TO: Jacob Dalton
PROJECT #: 22-1659-A
PAGE: 1 of 3
DATE: November 19, 2024
LOCATION: Dalton Residence Yellow Brick Road, Pittsboro
PLAN REF: Dalton Residence by Diane Rives Design
Project# 22-1659

THE FOLLOWING CHANGE(S) OR PROPOSED CHANGE(S) LISTED BELOW ARE DEVIATIONS OR CLARIFICATIONS FOR THE ABOVE REFERENCED PLANS:

**ROOF STRUCTURAL PLAN**

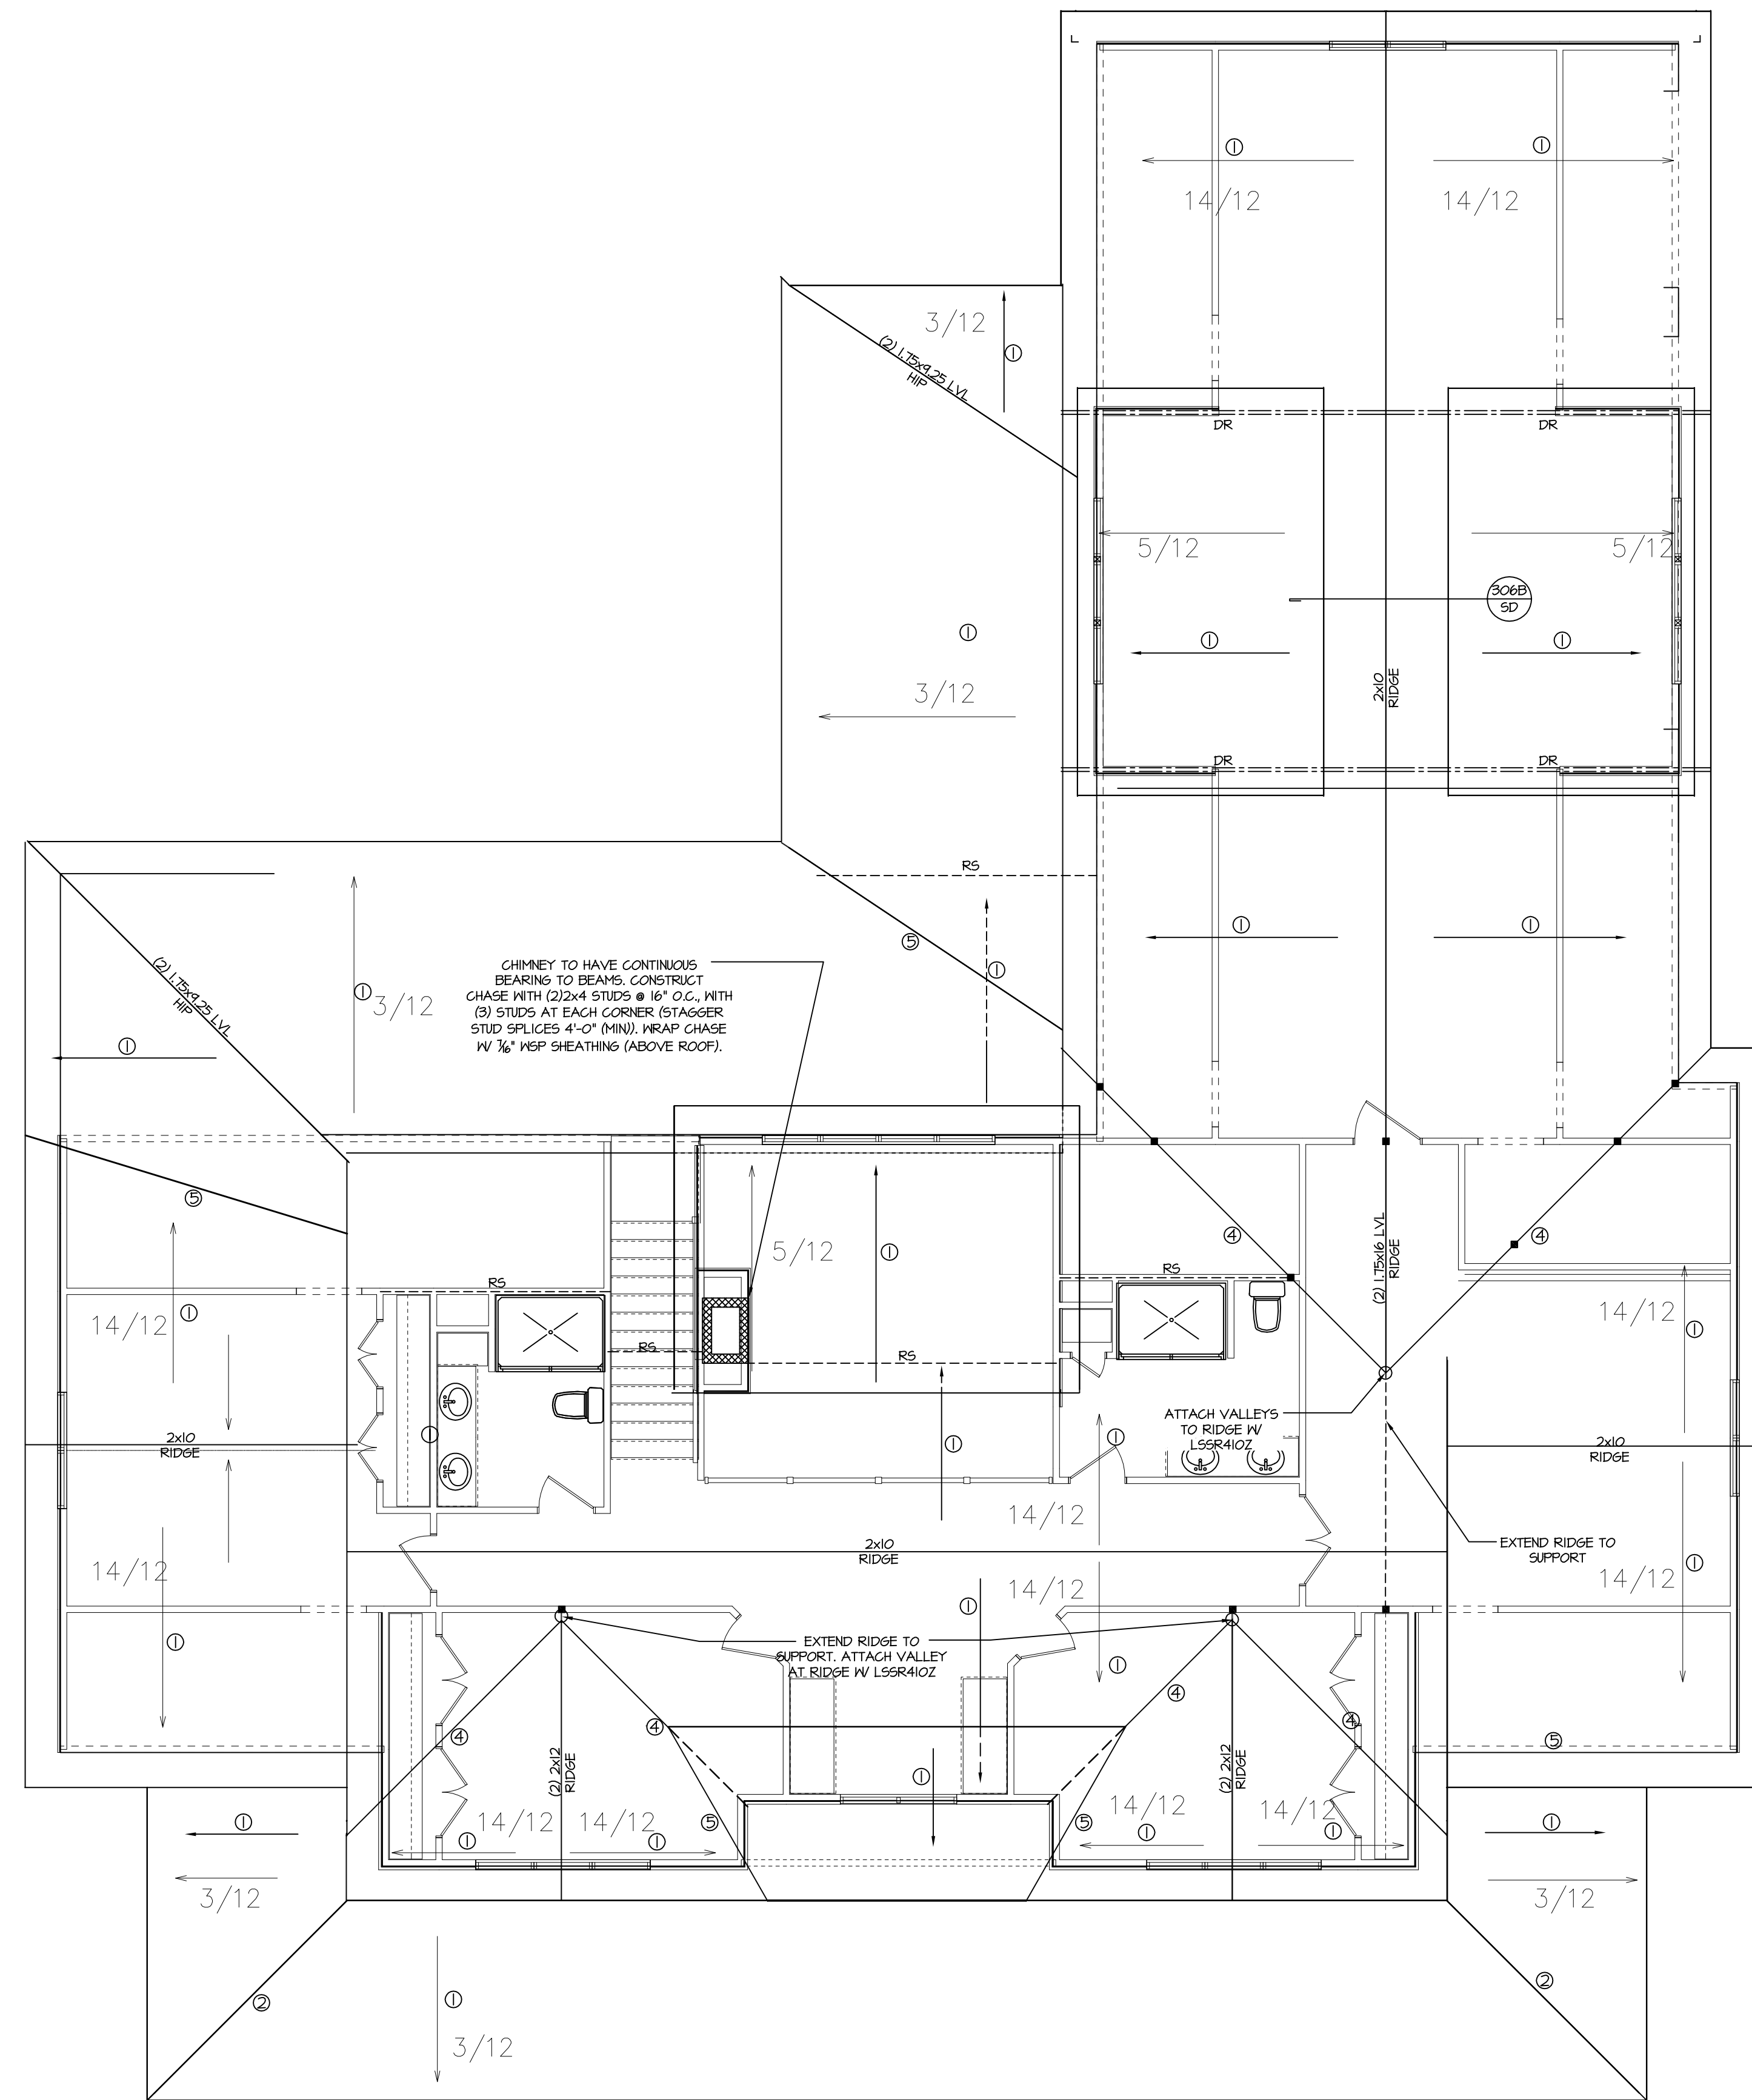
A. Shed Roof Modification: The original plans specify a shed roof at the front of the house. Per information provided by the builder the shed roof was not installed. The (3) 2 x 10 that was there to support the shed roof was omitted.

Response: Please note that omitting the (3) 2 x 10 described above is acceptable.
